File Name: ISH4 27th September Part 4.mp3
File Length: 01:52:28

Okay at the time is now 325. It's time to continue with issue specific hearing number four.

Thank you. Okay. So moving on to agenda item ten. Transportation and traffic. Item In relation to the traffic regulation measures,

C:\USERS\GFLETCHER\PTV\PT - CAD\LDA_49902002_MALLARD_PASS SOLAR FARM\CAD11.0.CURRENT\11.0.1.SHEETS\PROWS\4990-2001-T-079-089-P1 - TRAFFIC REGULATION MEASURES PLANS - TEMPORARY MEASURES.DWG

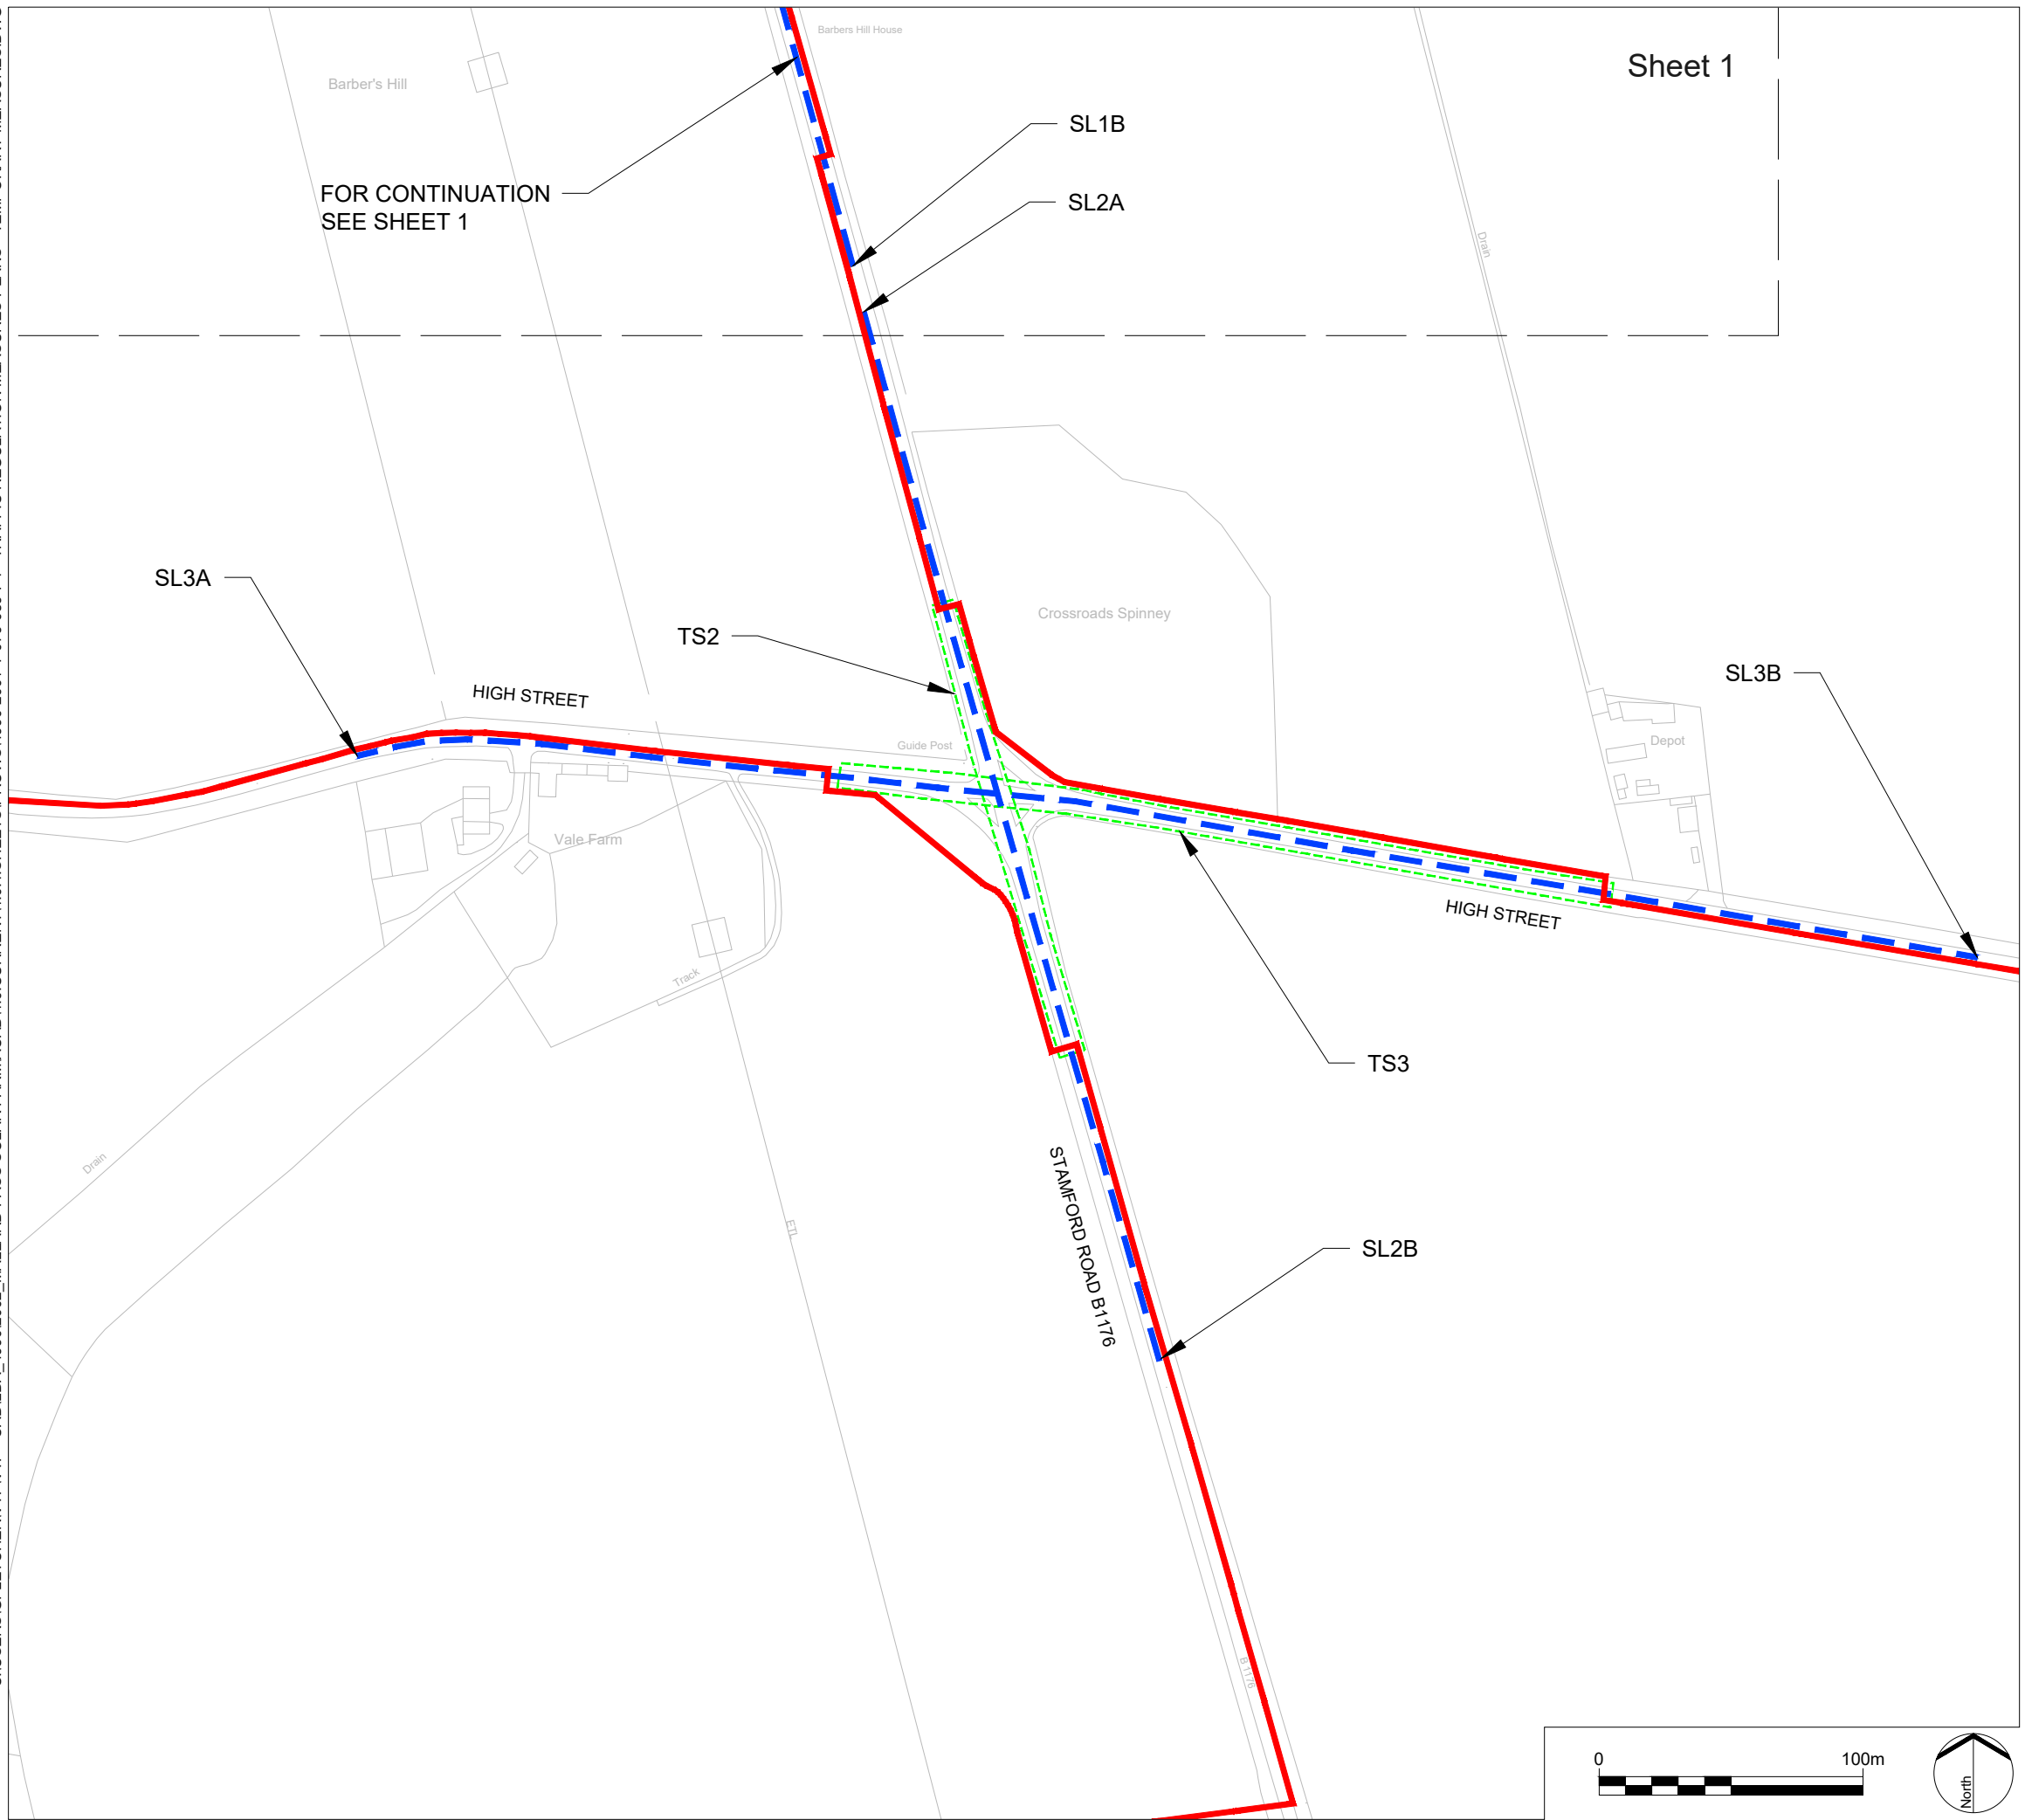
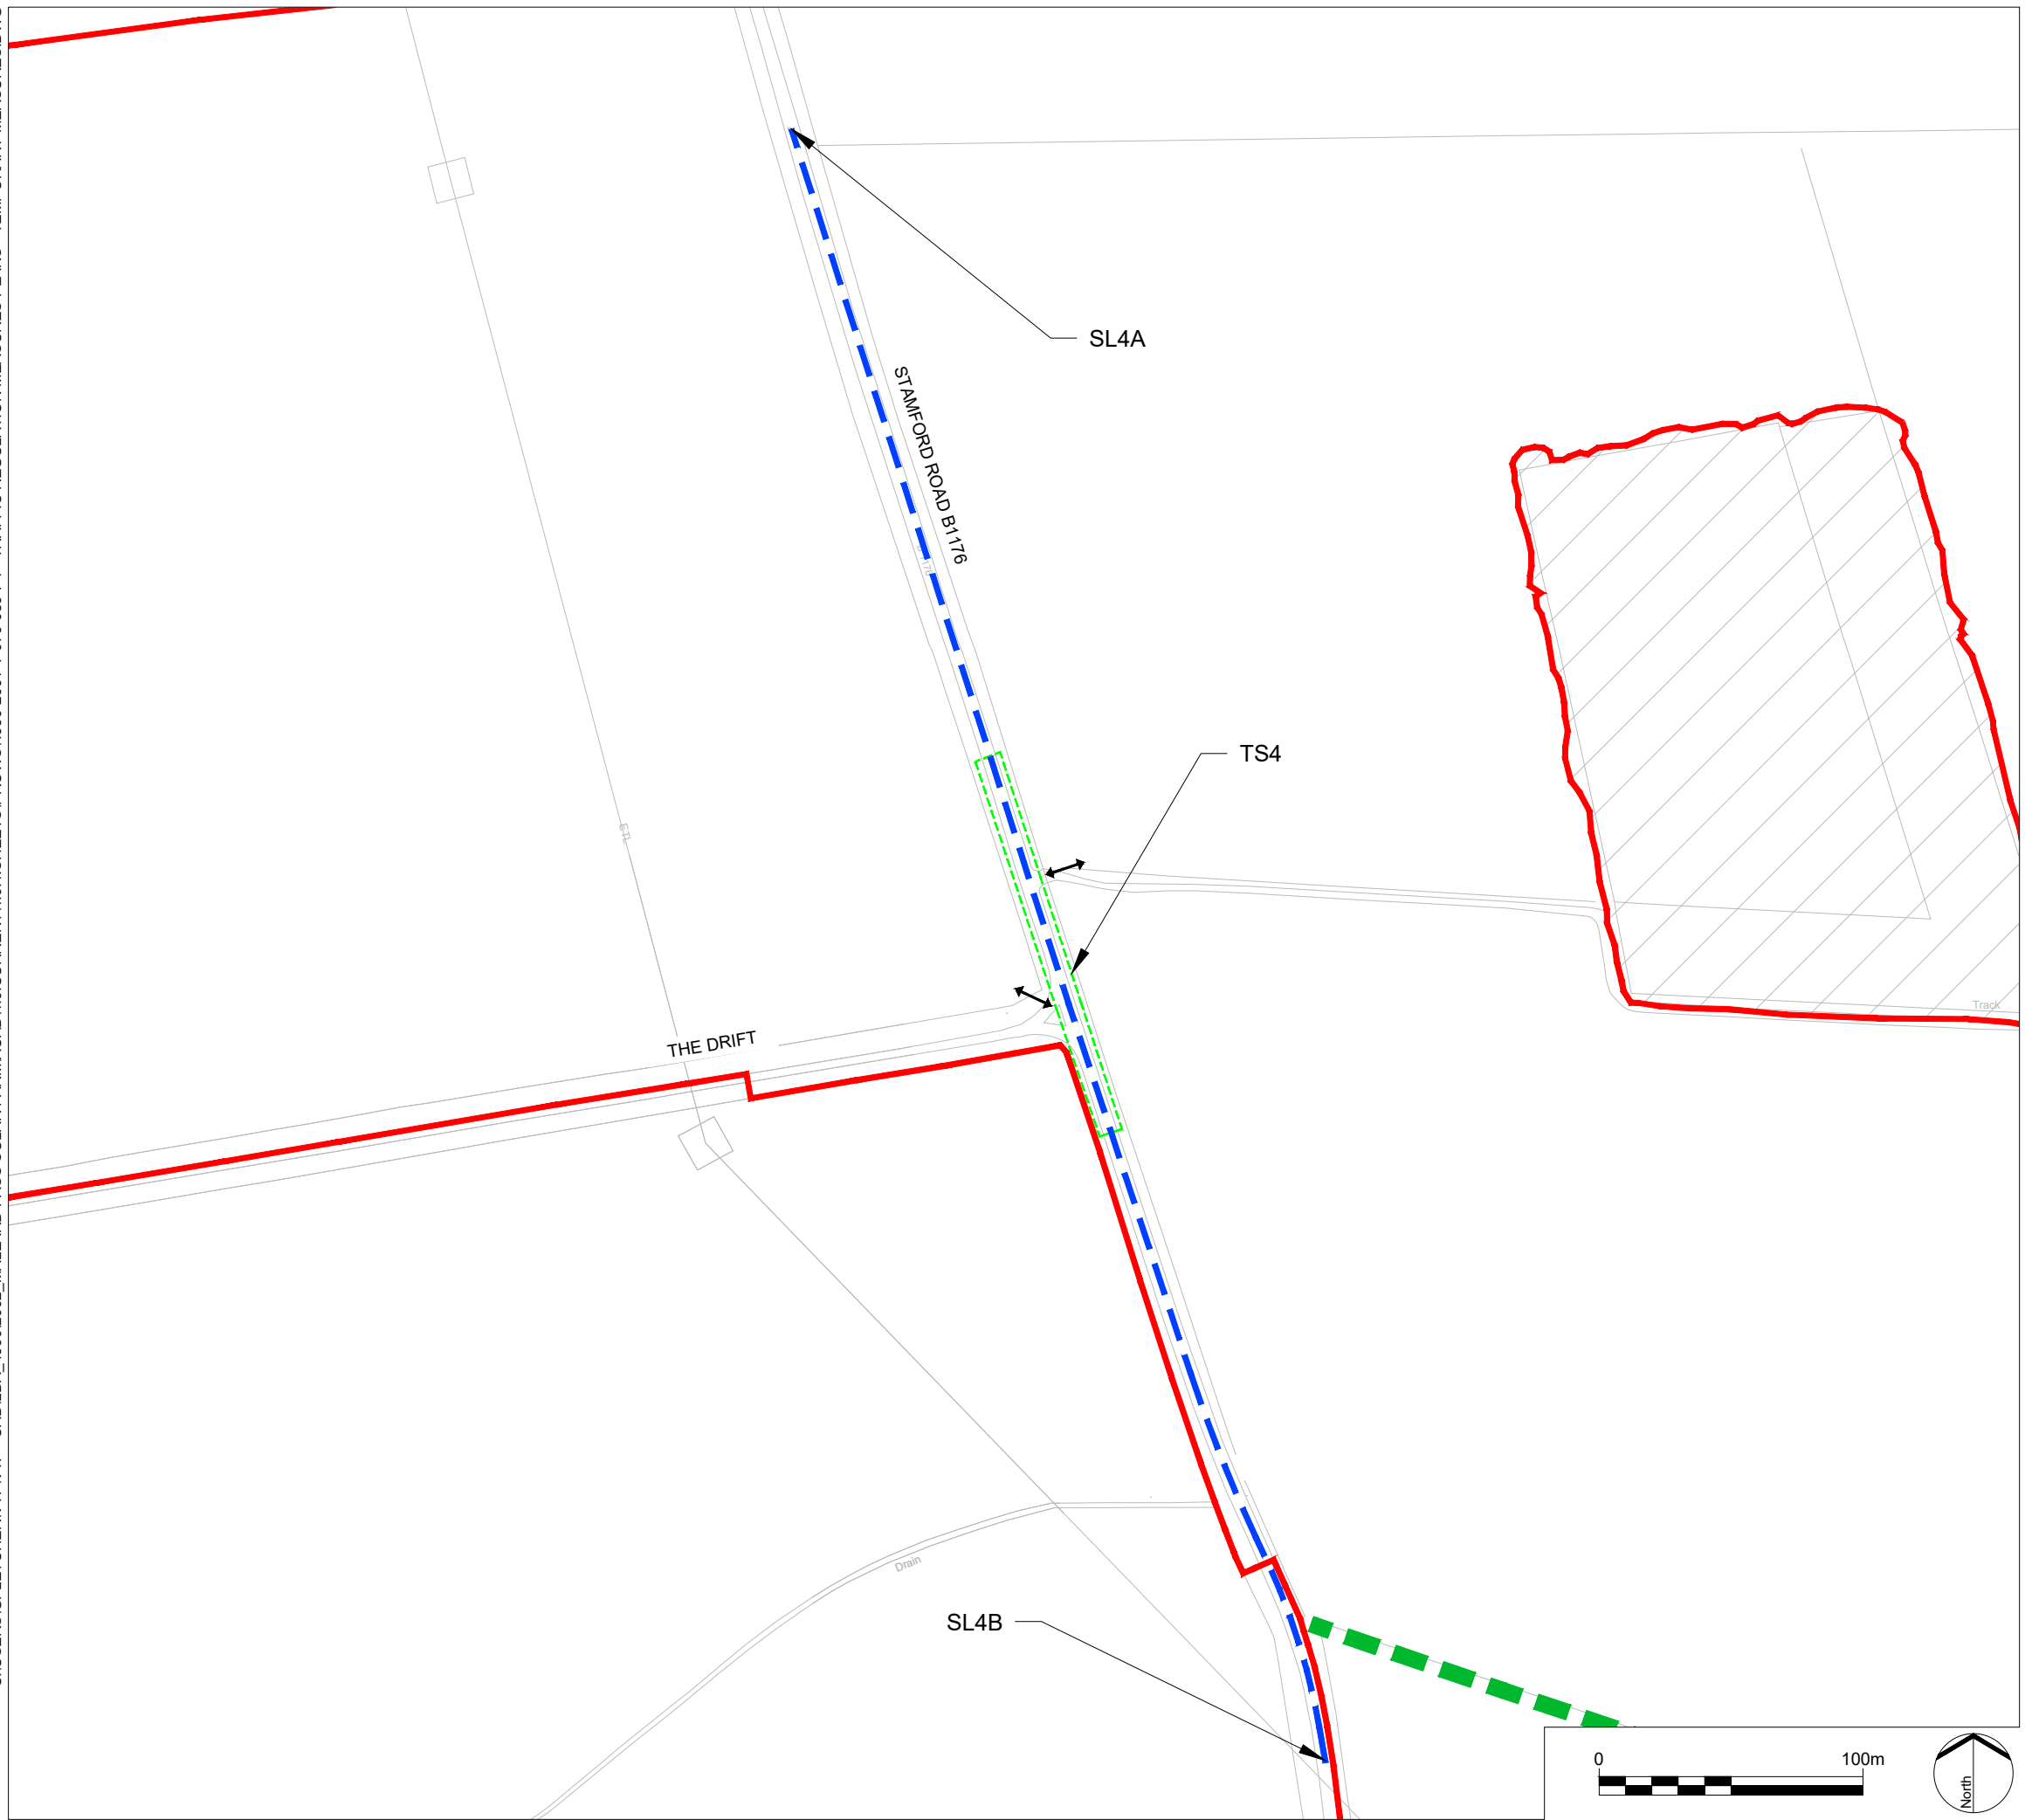
one in relation to the extends the temporary measures along Bond Road in S9. And just to point clarification in terms of the the of the proposed 30 mile an hour speed limit, which seems to replicate the existing 30mph speed limit through. Essendon. I don't know if they could. Perhaps just clarify that point. Also, note from the outline construction traffic management plan, paragraphs 4.7.1 and where it refers to a 20 mile an hour speed limits, whereas the other plans refer to a proposed 30,000,000 hour speed limits, which again, as I say, mirrors the speed limits already in existence through the village.

And it's the clarity that can be provided from that point. I think it's one of the concerns or issues that you raise being a point that could be quickly rectified earlier on in the day. So, Mr. Fox, if you could like to deal with that, please.

Yeah, I will bring Mr. Chancellor, But in my initial reaction is I think that is an error on the plans and they should read a 20 to be consistent with the TMP and the DCA. But I'll just get Mr. Ricky to confirm that.

Hi, everyone. Claudia Rich, on behalf of the applicant. Yeah. Believe that's a typo. We need to amend the plan.

To 20 miles an hour.

Figure 3-1: Construction Routes Overview

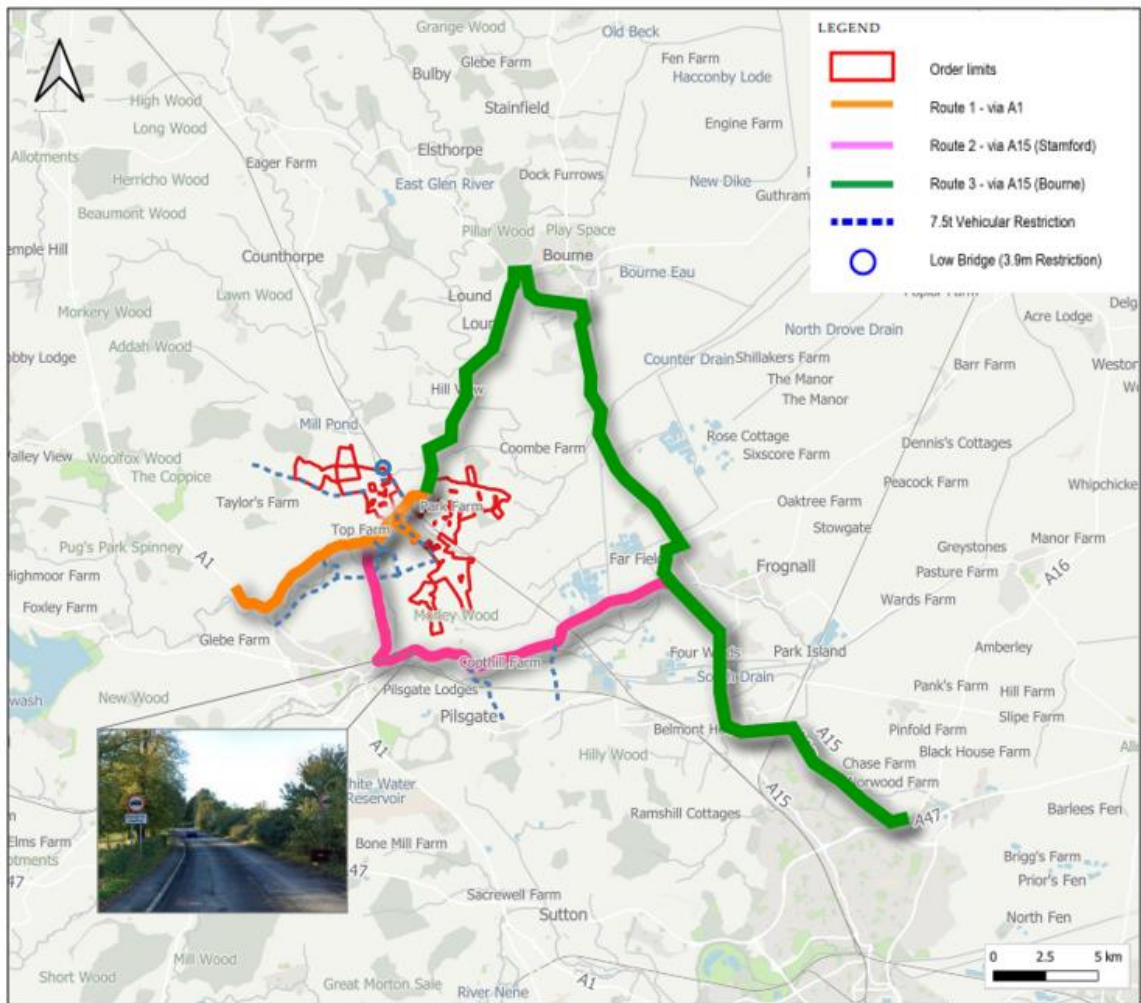
But it brings me back to the routing plan, which is a fundamental aspect of the whole construction process for this scheme, which if you just bear with me for a couple of minutes to explain it, and if you wouldn't mind if it's possible to bring up the latest construction contract. Construction traffic management plan I think is Rep 6-15. I had asked for it to be available on the deck.

Perfect knew exactly where was going. This is this has been updated, um, at the last deadline. It's just been a function of actually changing the colors around. However, the point wanted to raise was take a typical construction vehicle move and HGV movement, where it starts on the A1 at the start of the orange, goes on Route one through rail and to the substation. You can see it there in the middle of the site. And then it leaves the site has to leave the site on Route three.

So it goes out north on the green route all the way to Bowen and round and back past market Deeping heading up to Peterborough and then and then the green line just sort of abandons itself on the a47. Now if you started as an driver coming off at Great Casterton in the morning and that's your sort of starting point, head to the construction site and you've come from the north and you're going to have to get back to that point in the evening. So that green line should show it as a closed loop to back to where they start.

And that's 40 miles. Now, I just don't think it is feasible to expect all these lorries to leave the site en route three, if they were coming from the west or from the north on the A1 and have to go all the way back round on a 40 mile loop to then head off on their whatever it is homeward journey there, they're just not going to do it. It's, it's, it's not practical. It's actually not even fair on the drivers to expect them to do that and don't understand why.

The Route three green line just sort of finishes abandoned on the a47. Because they obviously start at the point of the orange line potentially, that, you know, they could come from any other part of the site. But it is a huge loop and you can see that just by the length. If you look at Route one in to the site versus Route three out, and that's not even completing the loop. So, you know, whatever enforcement you want to put to ask these drivers, I would have thought any construction firm would be aghast, but expecting their drivers to do that.
